**Application for Approval of Details Reserved by Condition
Town and Country Planning Act 1990
Planning (Listed Buildings and Conservation Areas) Act 1990**

Discharge of conditions 3 (detailed drawings), 4 (additional storey), 5 (materials), 6 (residential waste), 7 (A3 use waste), 9 (swift nesting), 14 (ventilation), 15 (noise assessment) and 19 (air quality) of previous permission 2019/92962 for erection of additional storey and conversion of building to provide 23 self-contained apartments and A3 use in basement and part of ground floor (Listed Building within a Conservation Area)

Field House, 15 Wellington Street, Dewsbury, WF13 1BQ

Application Number: 2022/92236

**REFUSE STRATEGY
(RESIDENTIAL)**

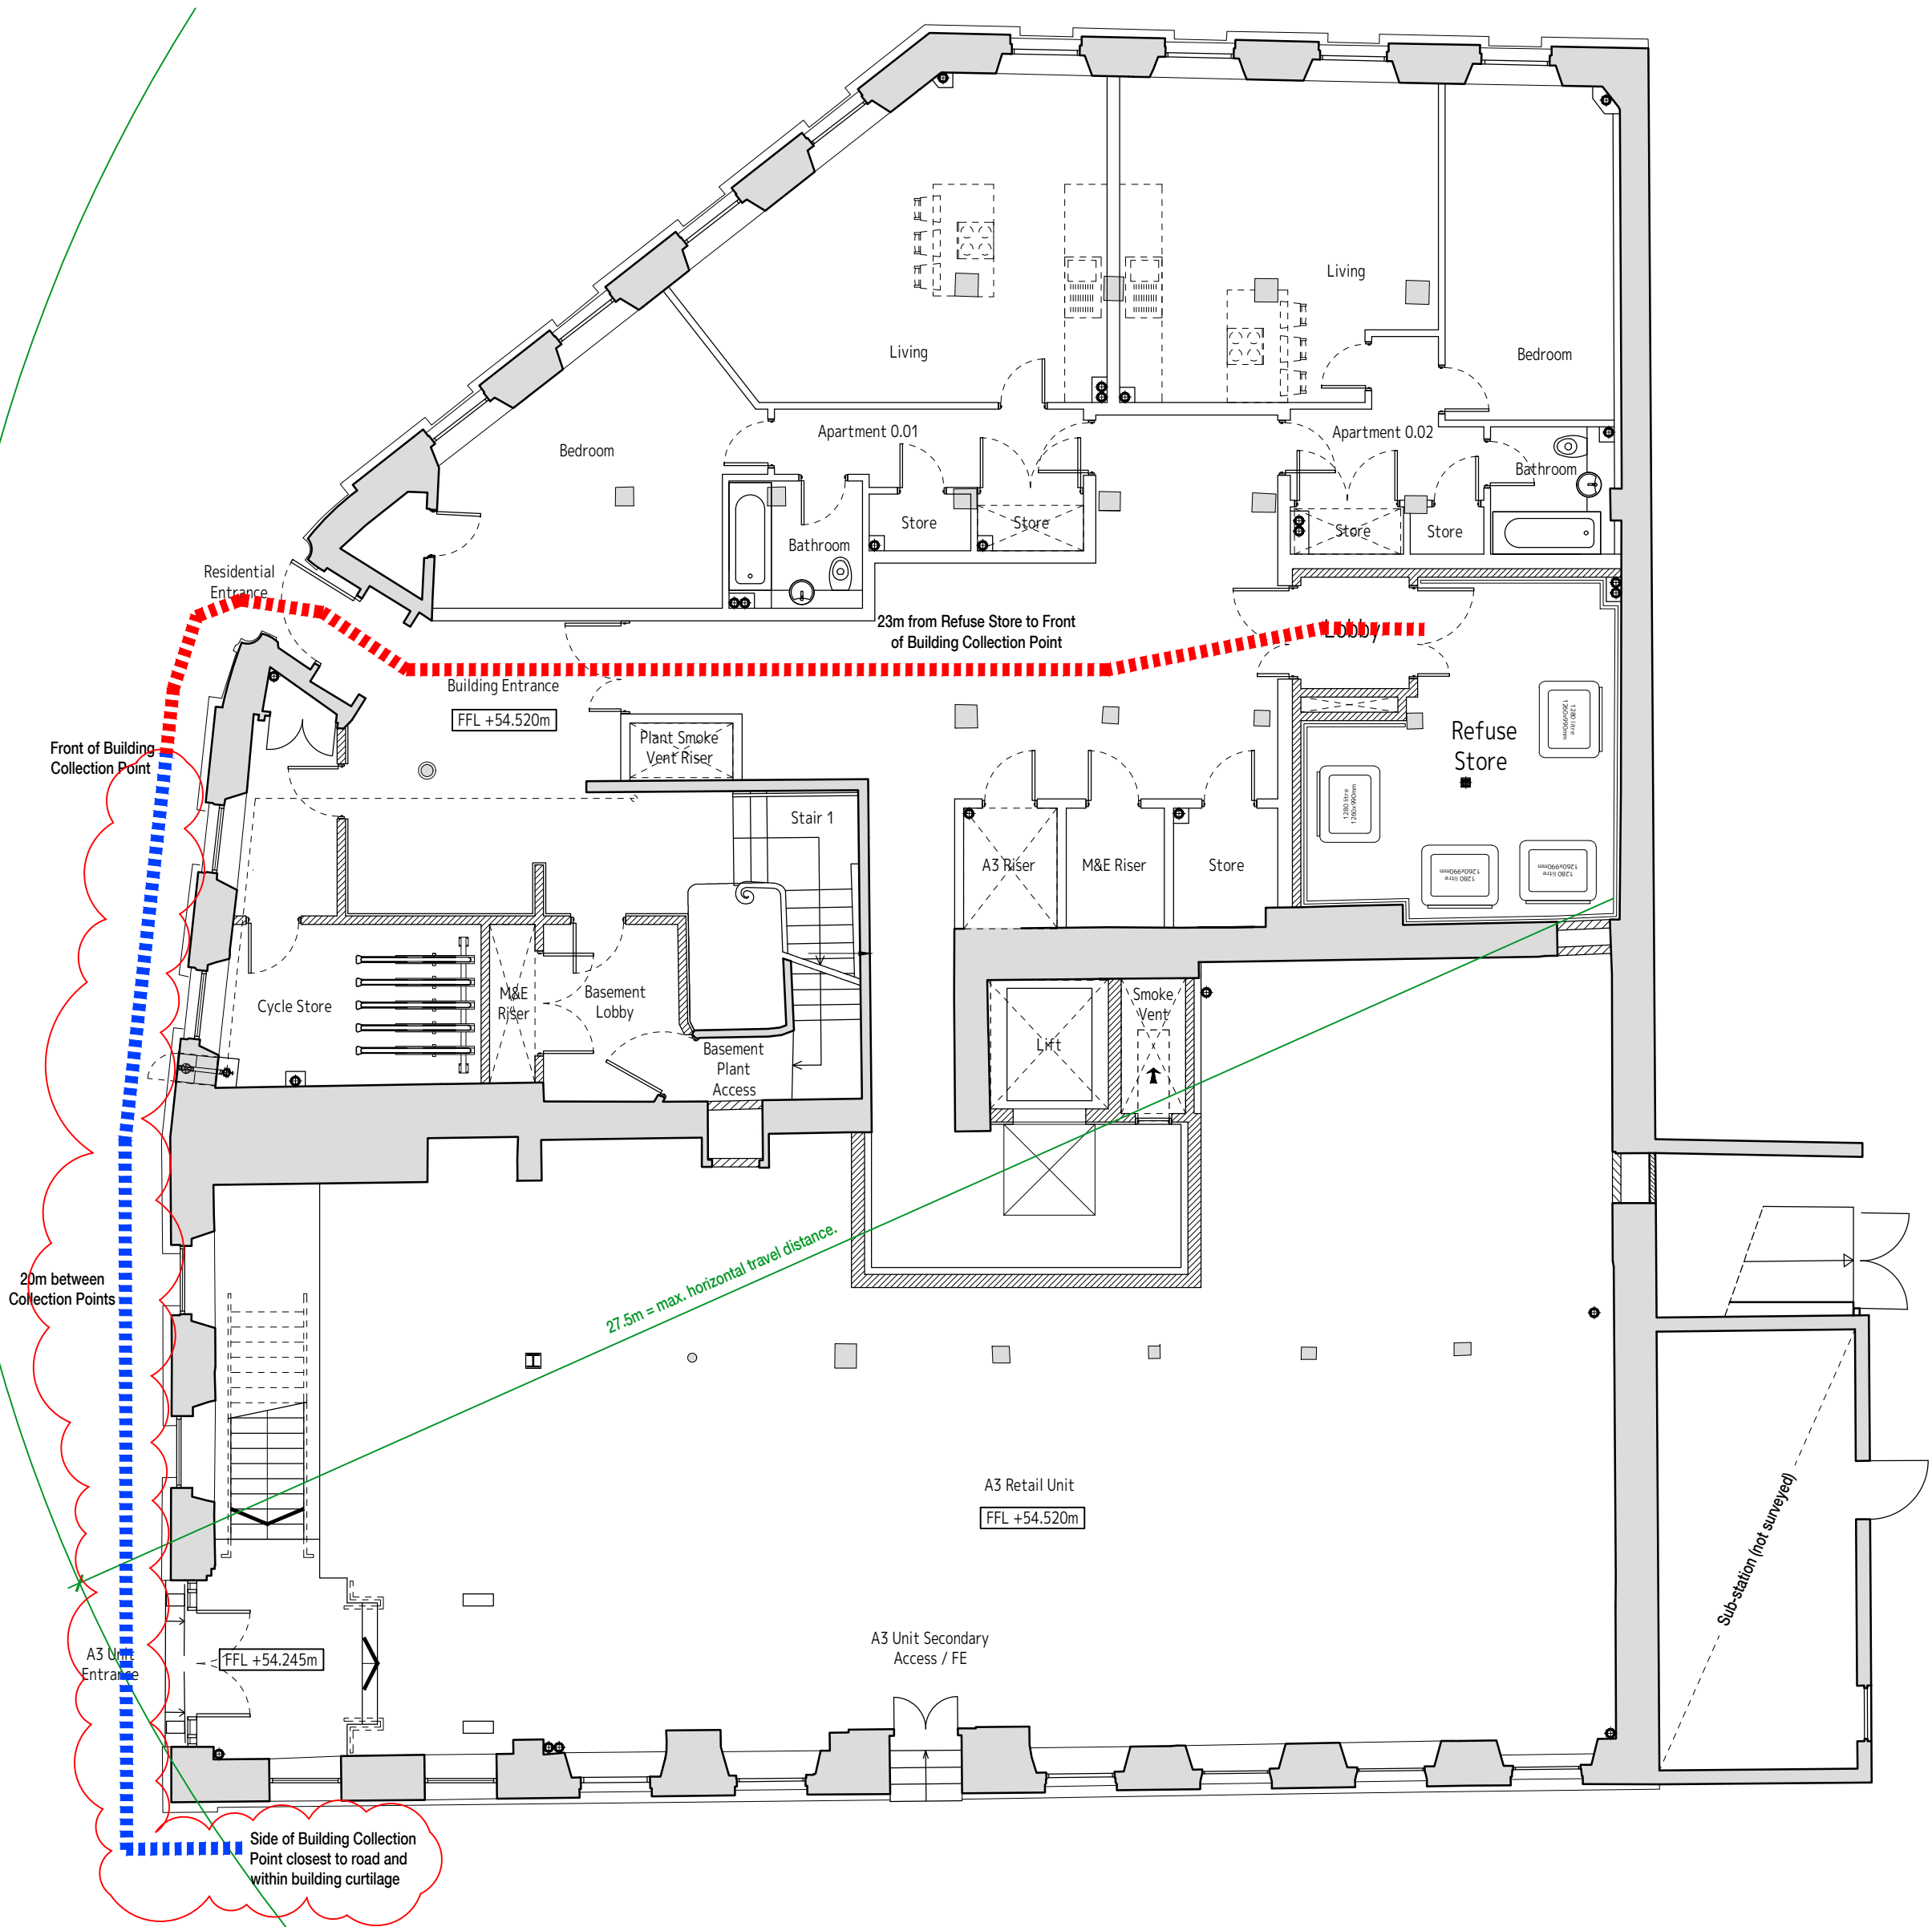
Condition 6 (residential waste) – You have submitted drawing 2018-051 0810 rev B titled "Refuse Strategy (Residential)", and you have confirmed that bins would be wheeled out to the proposed collection points and back again by the building management on the day of collection. These arrangements are considered acceptable, and are hereby approved pursuant to condition 6. Please be reminded, however, that condition 6 further stipulates that the approved details shall be implemented prior to first occupation of any part of the residential use hereby approved, and shall be so retained thereafter unless otherwise agreed in writing by the Local Planning Authority.
